Cheshire West and Chester Council's response to Table 2-6 of the Applicant's Comments on Submissions Received at Deadline 3 [REP4-263] (Response to Cheshire West and Chester's Written Representation submitted at Deadline 1 (17 April 2023) [REP1-061] and subsequent responses at deadlines 2 and 3).

Submitted at Deadline 5 – Tuesday 4 July 2023

This is a composite document across all deadlines and represents a table of responses to the Liverpool Bay CCS Limited ("the Applicant's") response to the Cheshire West and Chester Council's ("the Council") Written Representation originally submitted at Deadline 1 (17 April 2023) and subsequent responses at deadlines 2, 3 and 4, in respect of the Applicant's application for development consent for the Hynet Carbon Dioxide Pipeline DCO ("the Project").

**DRAWING TITLE**  
**WORKS PLAN REGULATION 5(2)(i) APPLICATION DOCUMENT REFERENCE D.2.4 SHEET 1a**

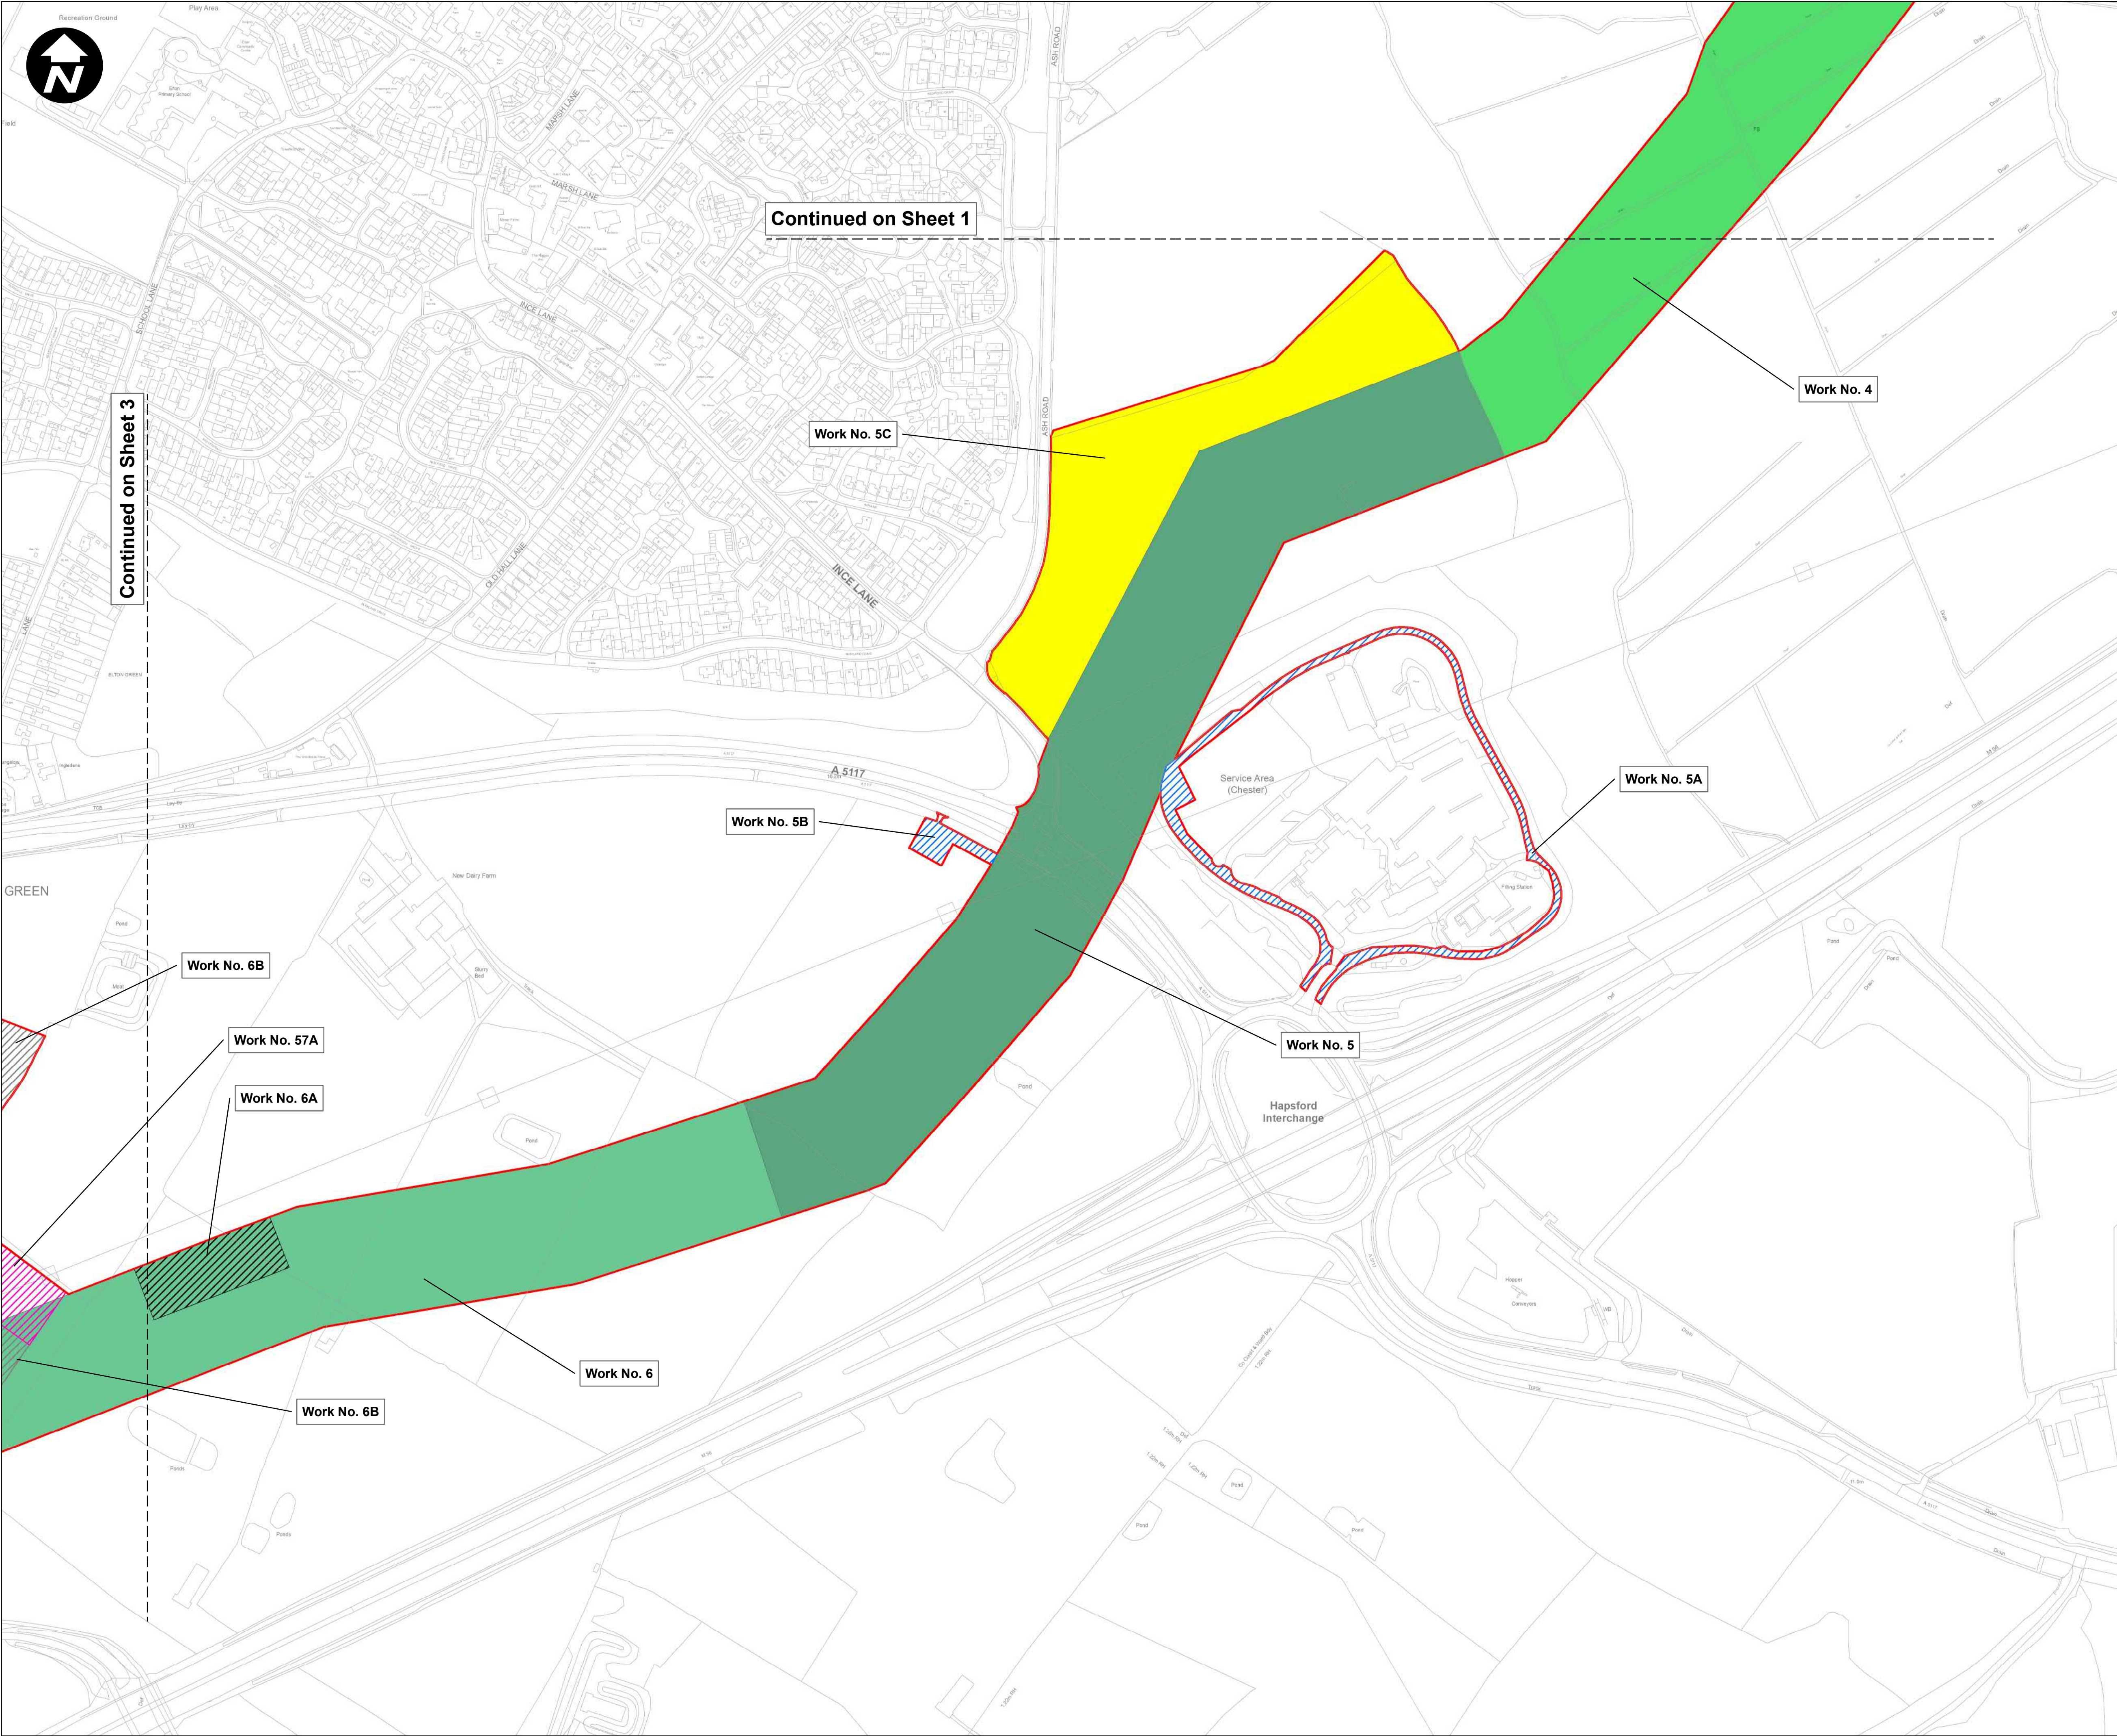
Ref	WR Ref	The Council's Witten Representation (WR) Deadline1	Applicant's Deadline 2 Comments	Council's Response at Deadline 3	Applicants Deadline 4 Comments	Council's Response at Deadline 5
				 <p>Work No.3, EN070007-D.2.4-WP-Sheet 1 (Rev D) [REP2-005].</p> <p>The Council would welcome engagement and constructive dialogue from the Applicant on these matters.</p>		
Mineral Safeguarding
